29 June 2018

**RE: CLEAN TEQ SUNRISE PROJECT OPTIMISATION MODIFICATION (MOD4) –  
SHORT-TERM CONSTRUCTION PHASE WATER TRANSPORT**

Clean TeQ Holdings Limited (Clean TeQ) submitted the Clean TeQ Sunrise Project (the Project) Modification 4 Environmental Assessment (the EA) to the Department of Planning and Environment in November 2017.

Figure 17

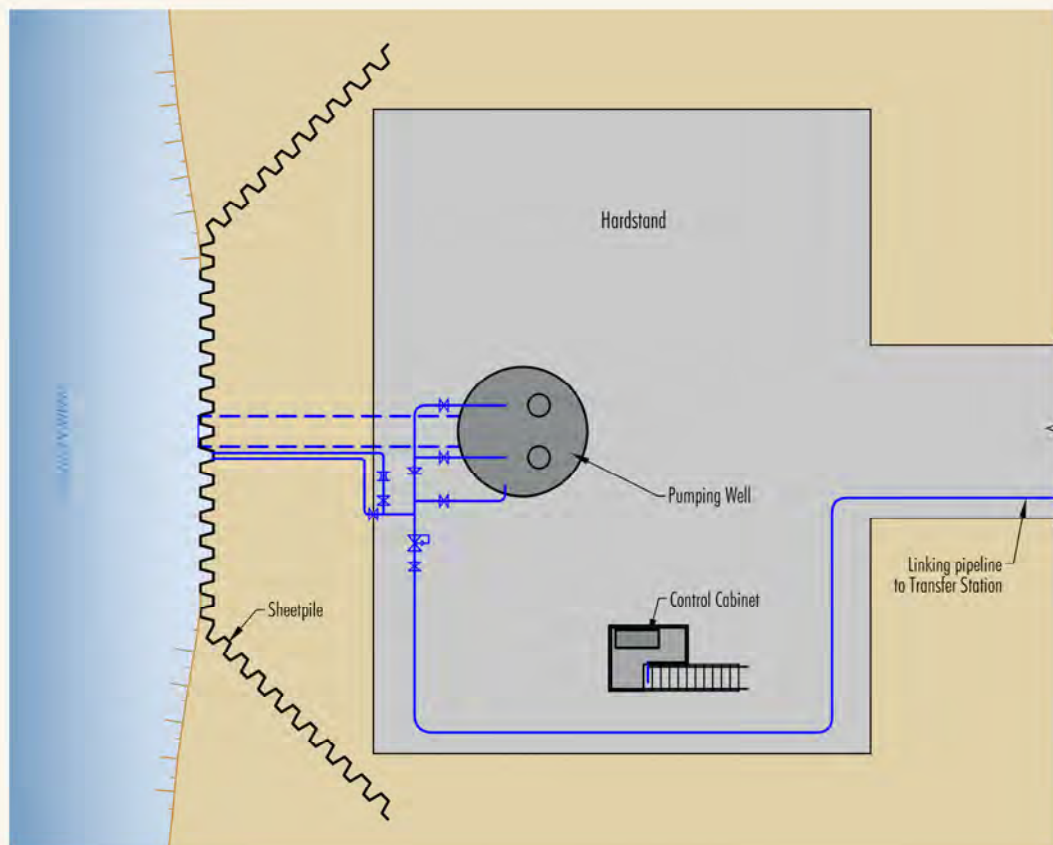
Since lodgement of the application, Clean TeQ has continued to review the costs associated with the construction water proposal, and, as mentioned in Section 3.9.3 of the EA, continued to consult with Forbes Shire Council about the transport route. As a result of this consultation and review, Clean TeQ has decided not to pursue approval for this proposal. Approval for the proposed truck loading area within the borefield transfer station footprint (refer to Section 3.9.3 and Figure 17 of the EA) would also not be pursued.

Based on the above, Clean TeQ requests that the proposed construction water transport component be excluded from the Modification 4 application and the Department of Planning and Environment continue assessing the application without it.
